OFFICIAL NOTIFICATION OF DECISION

Nicholas Blincoe Gallo Partners, LLC 4010 Carlisle Blvd. NE, Suite B Albuquerque, NM 87107 Project# PR-2020-004098 Application# MAJOR_PLT-2025-00006 PRELIMINARY/FINAL PLAT VAC-2025-00024 VACATION OF PUBLIC EASEMENT

LEGAL DESCRIPTION: For all or a portion of: Lot/Tract A1, BRIDGEPOINT zoned PD, located on BRIDGE BLVD SW between BRIDGE BOULEVARD and 86TH STREET containing approximately 4.54 acre(s). (K-09, L-09)

PRELIMINARY PLAT
ELEVATE ON BRIDGE

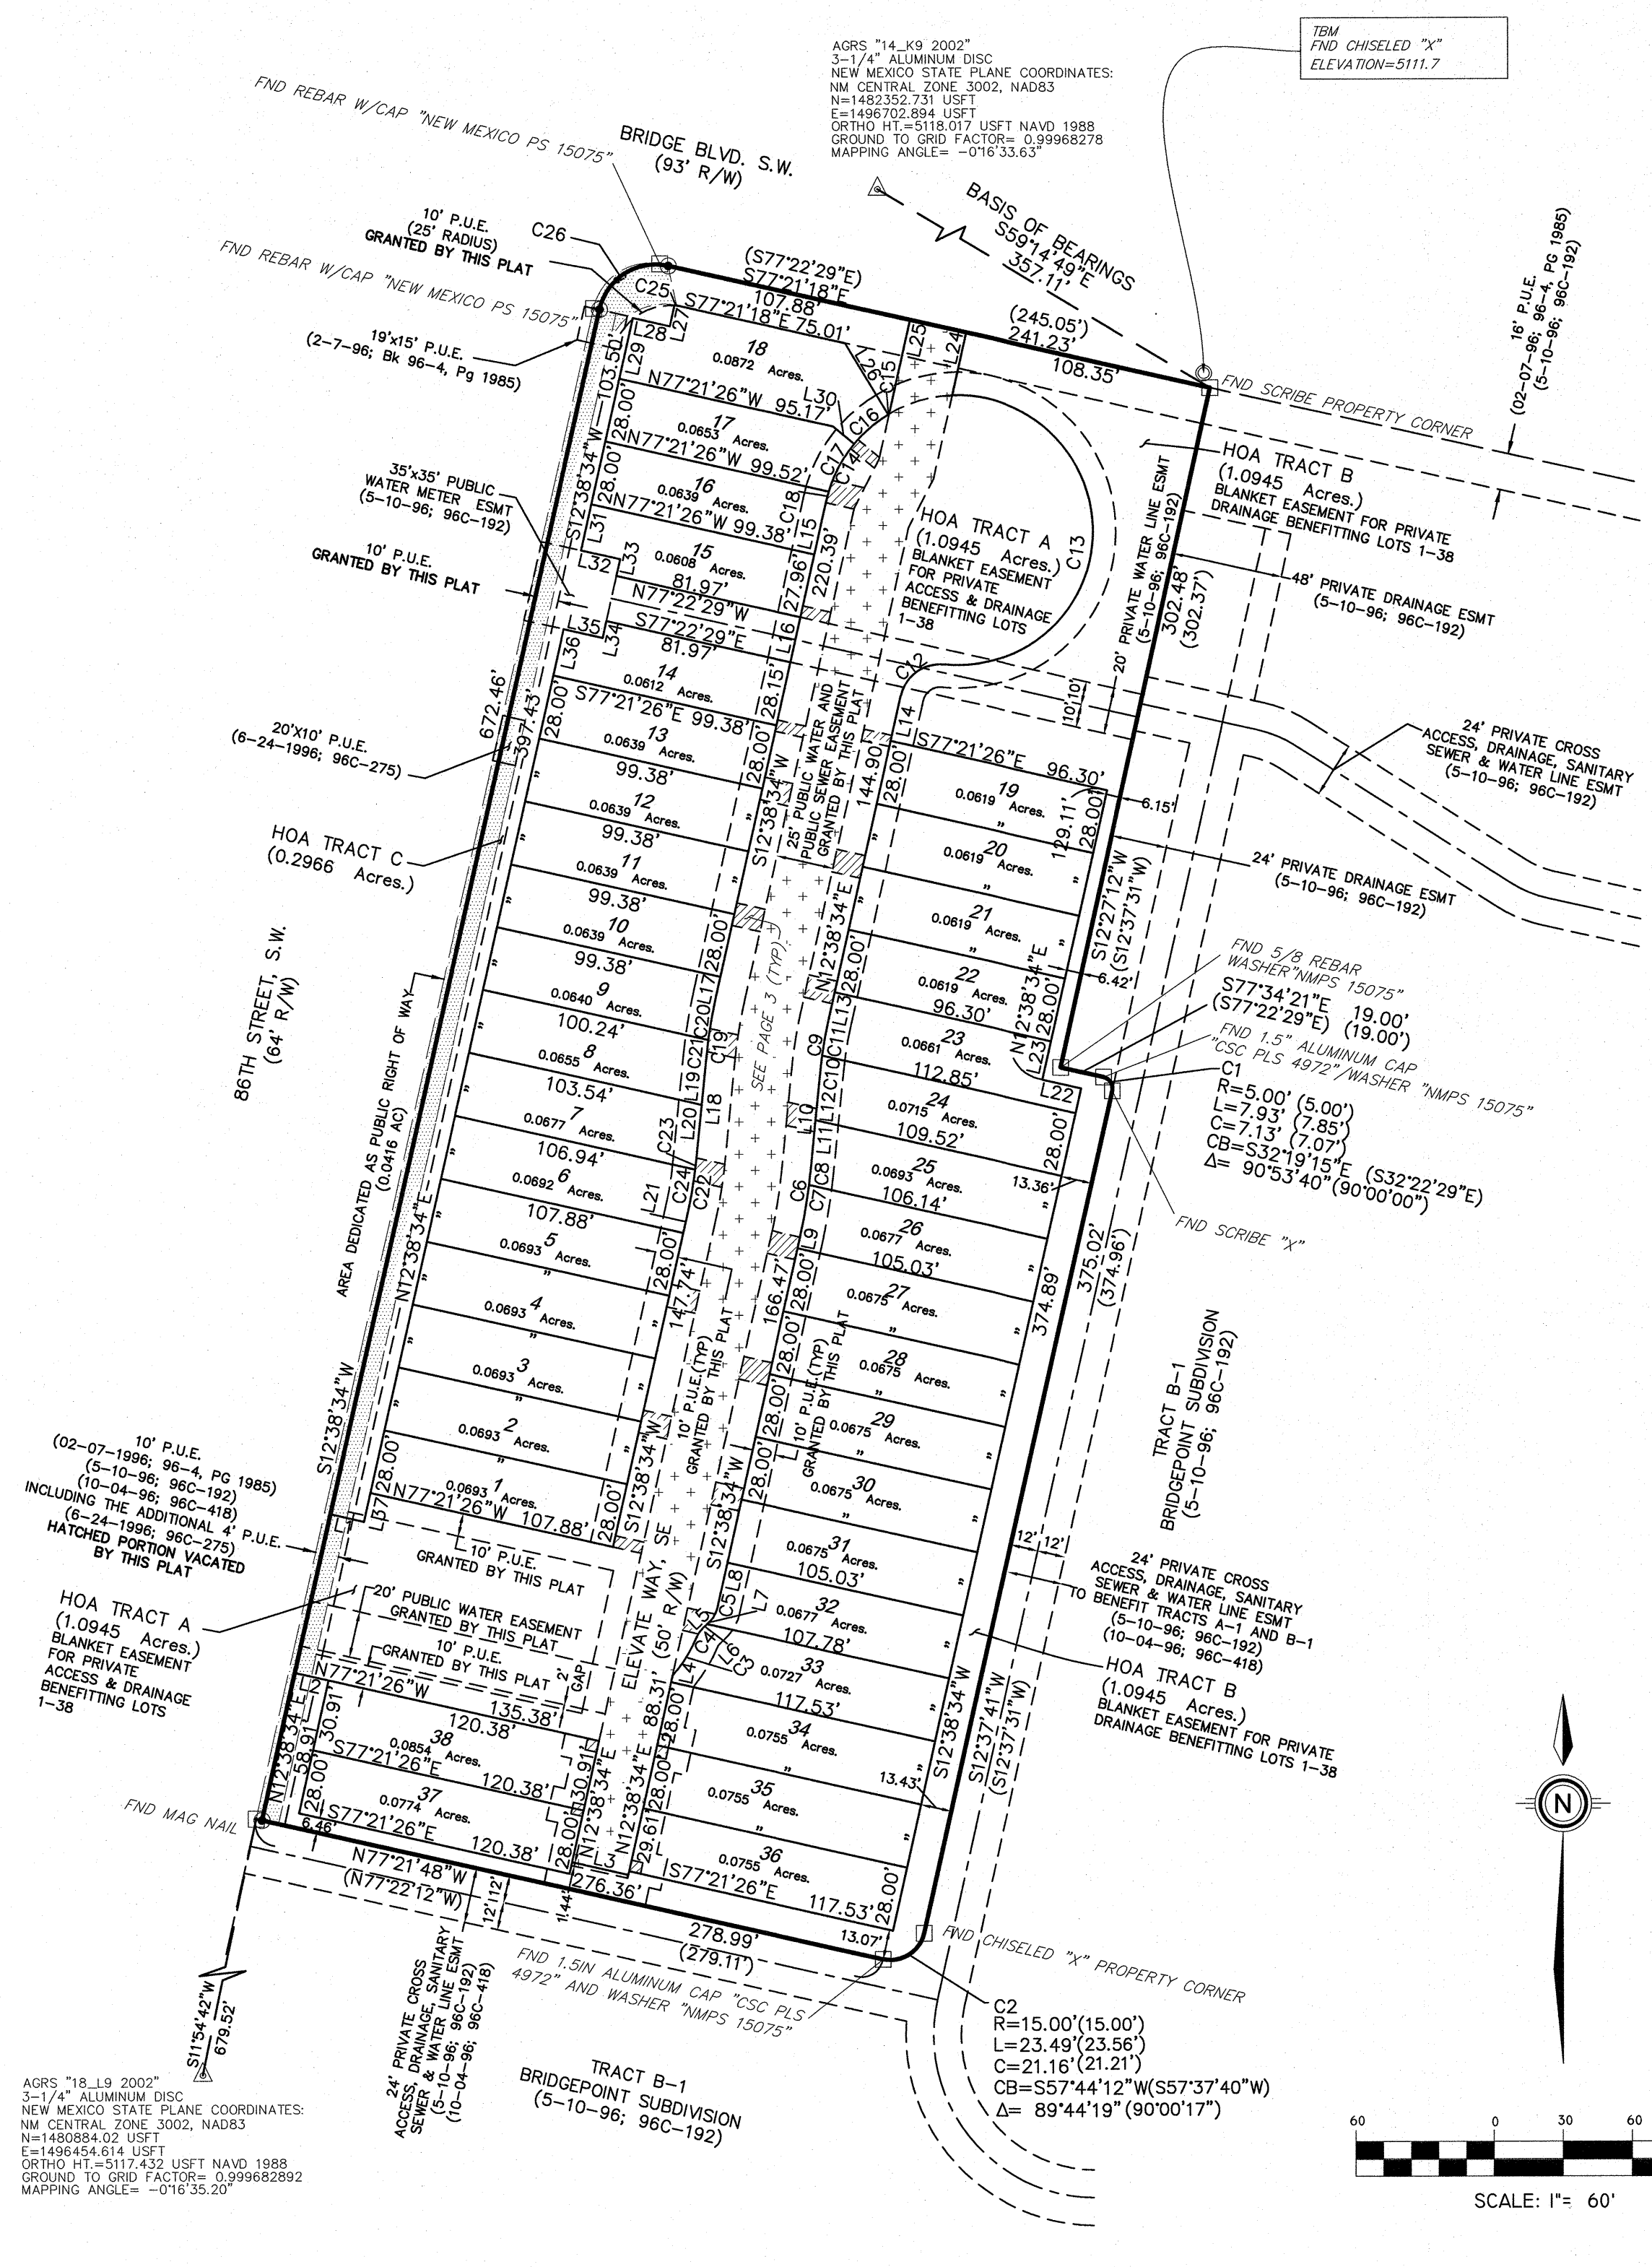
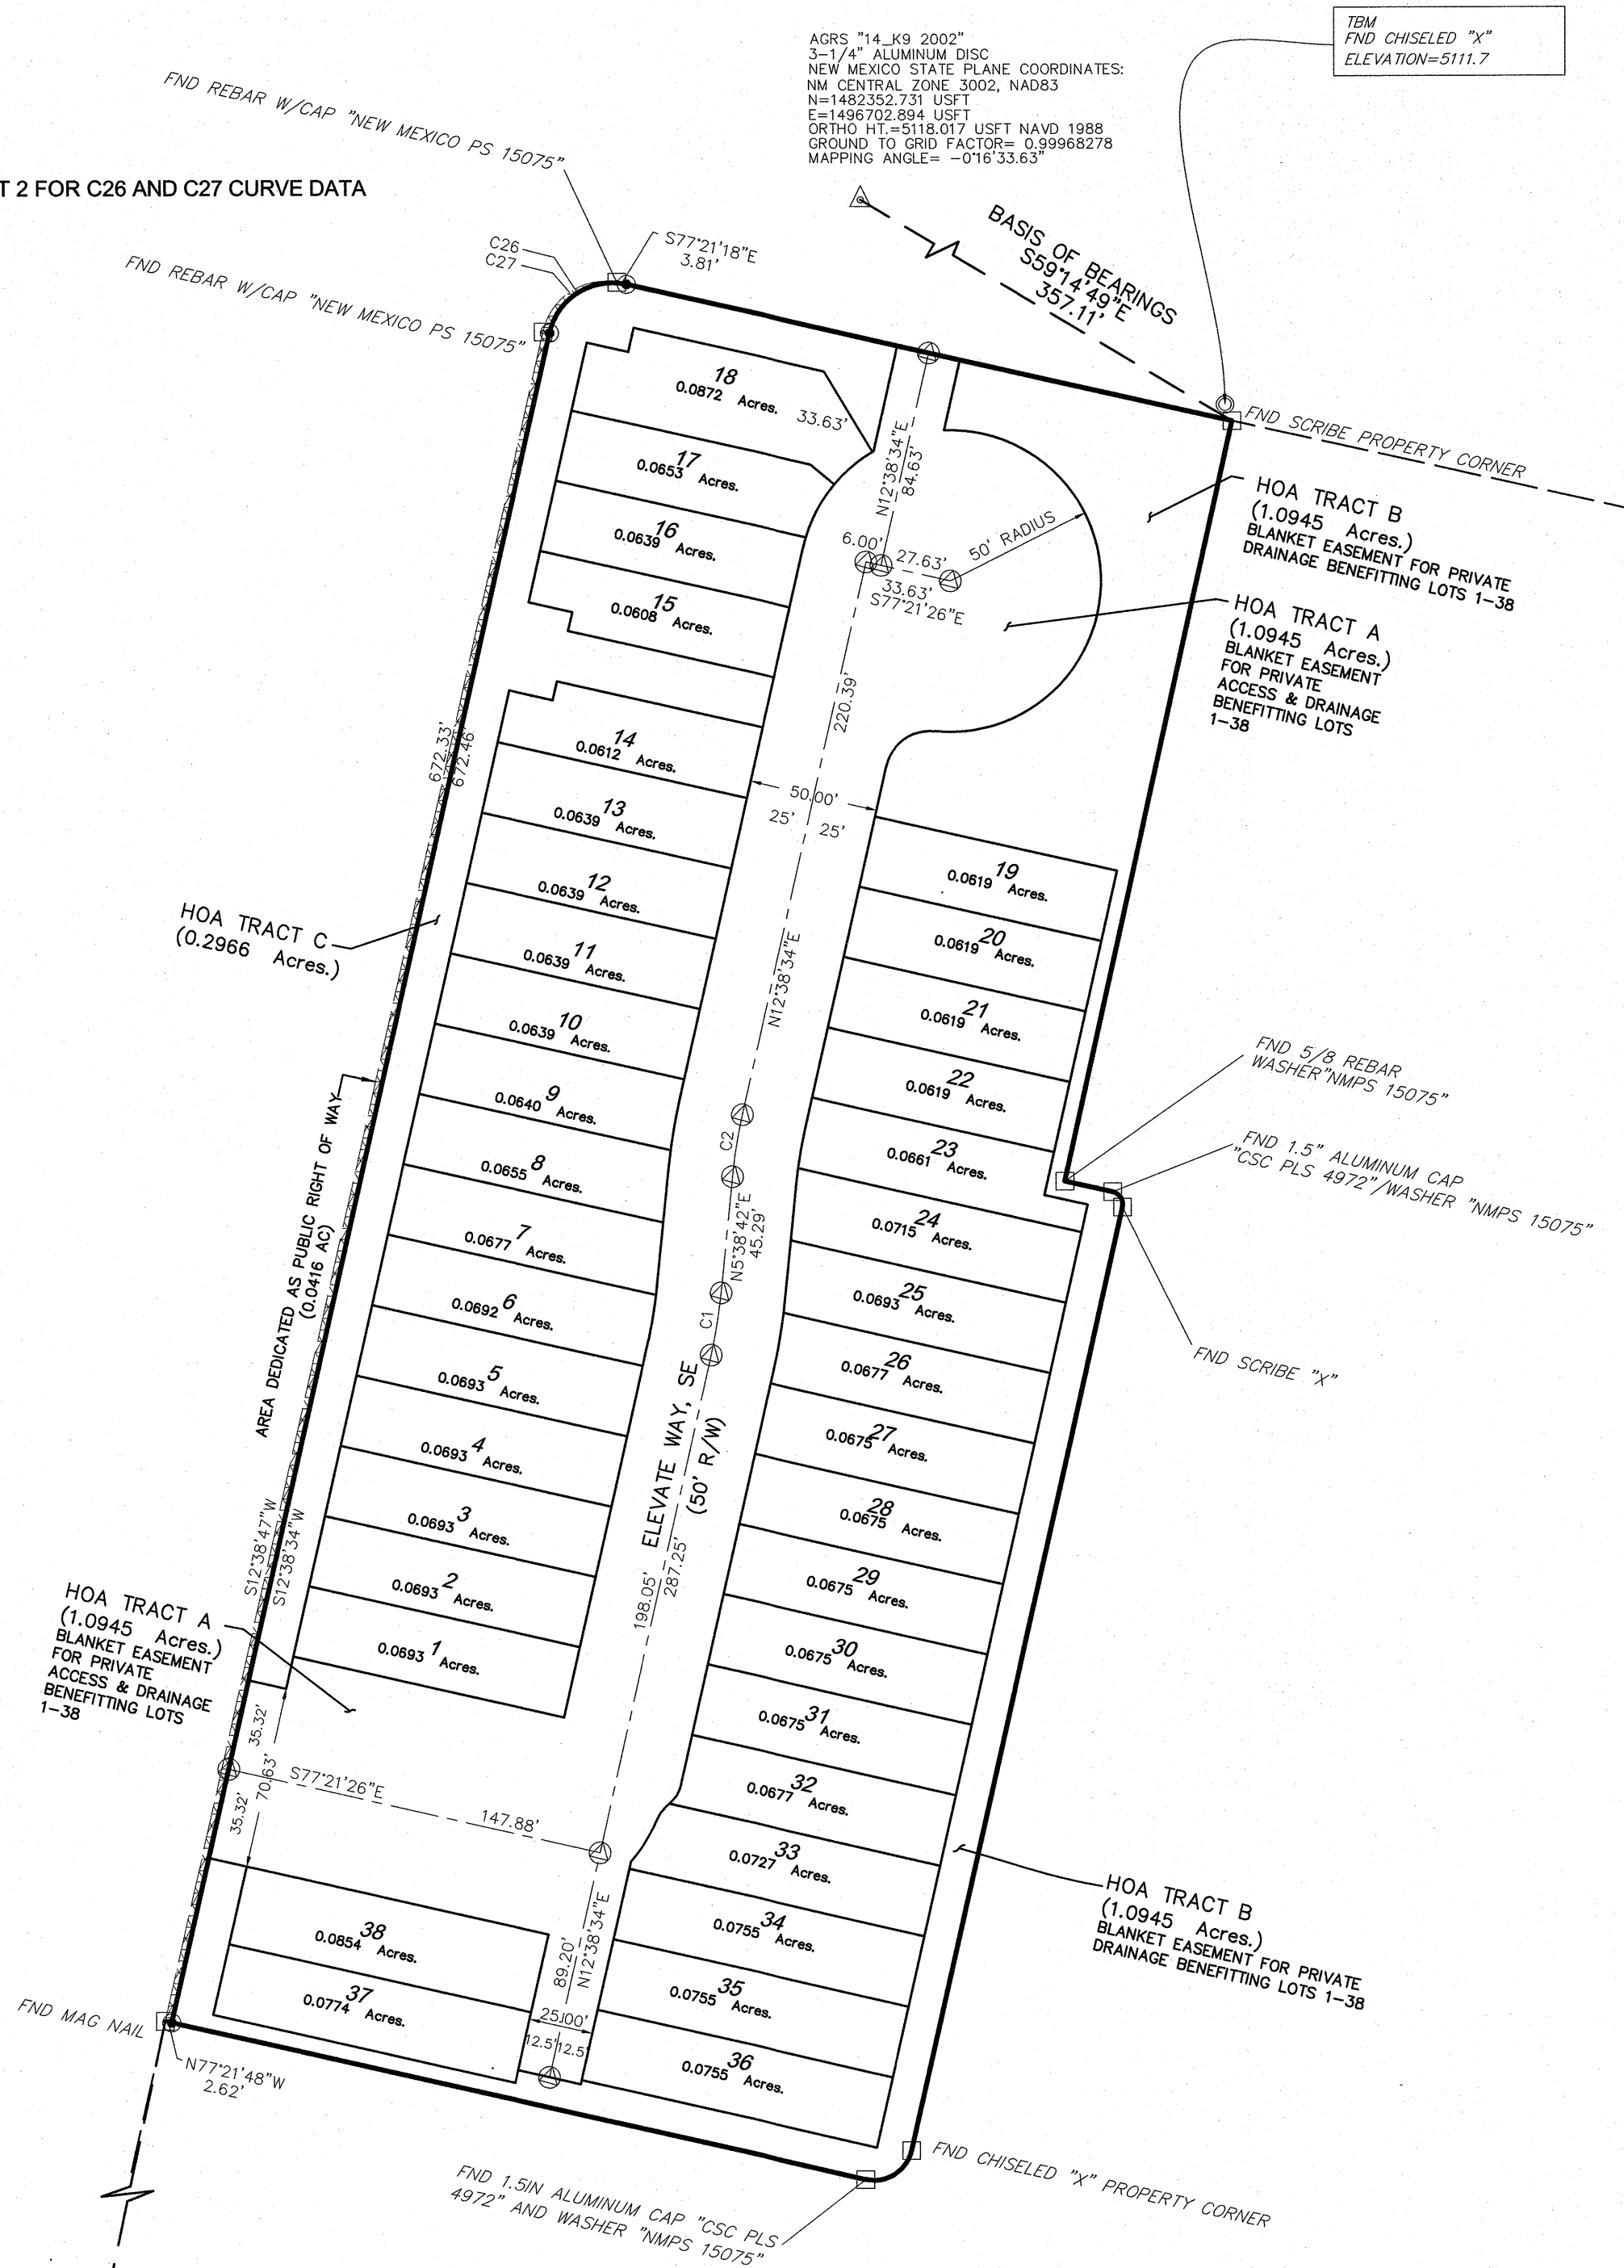
- 4. The plat shows ownership of the land as being owned by Landmark Lmtd. The applicant has stated that the parcel is owned by Gallo Partners and the exchange of ownership happened following the submittal of the plat.

- a. The application number must be added to the Plat.
- b. The date of the DHO approval shall be recorded on the Plat.

2 PROPOSED TYPICAL SECTION - BRIDGE BLVD SW SCALE 1:5

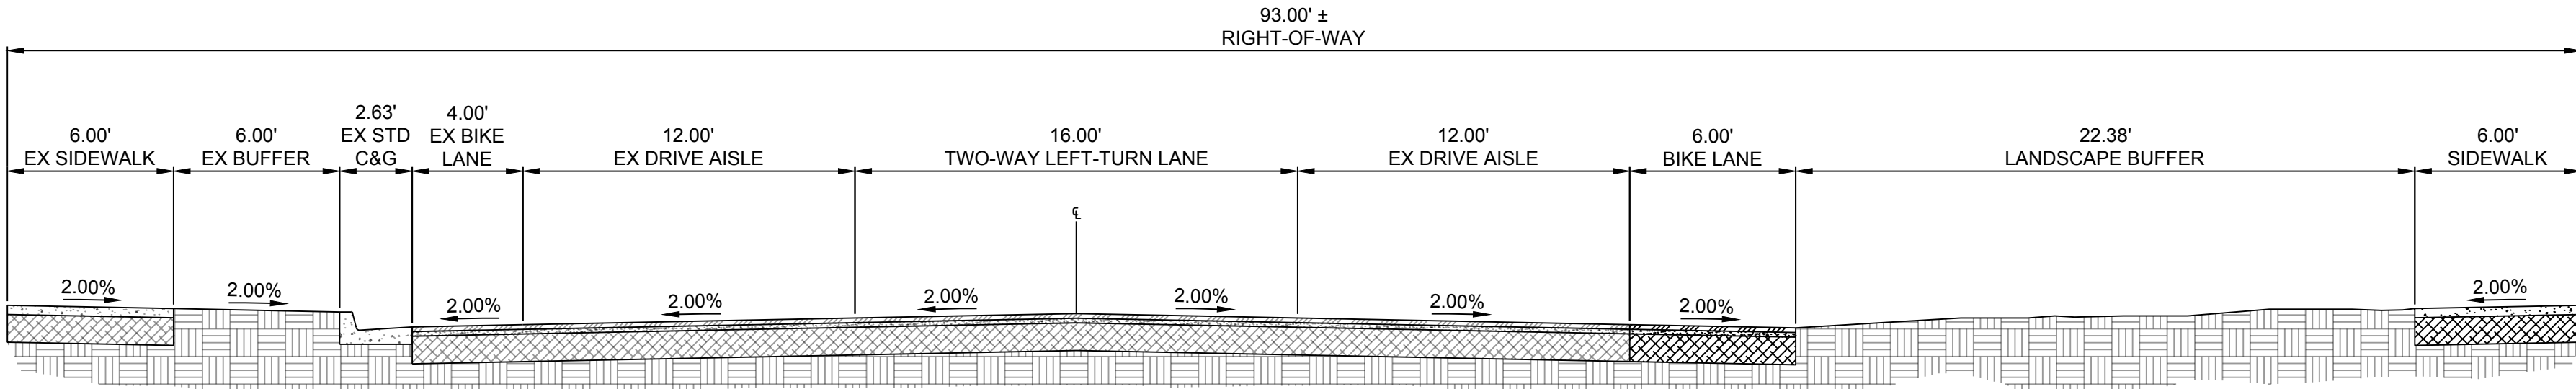
c. Add curb and gutter along Bridge to the infrastructure list.

EASEMENT  
VACATION  
EXHIBIT

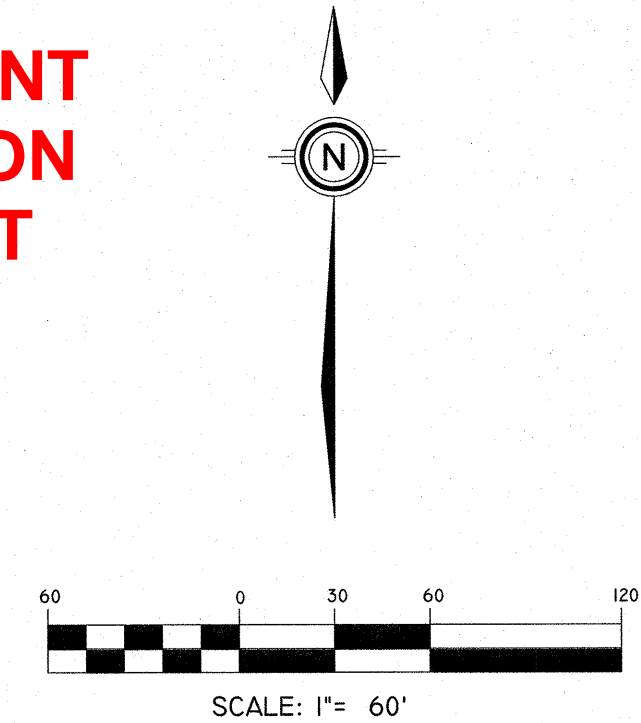
1. This is a request to vacate a 35-foot x 1-foot portion of a public water easement that will overlap the new right-of-way.
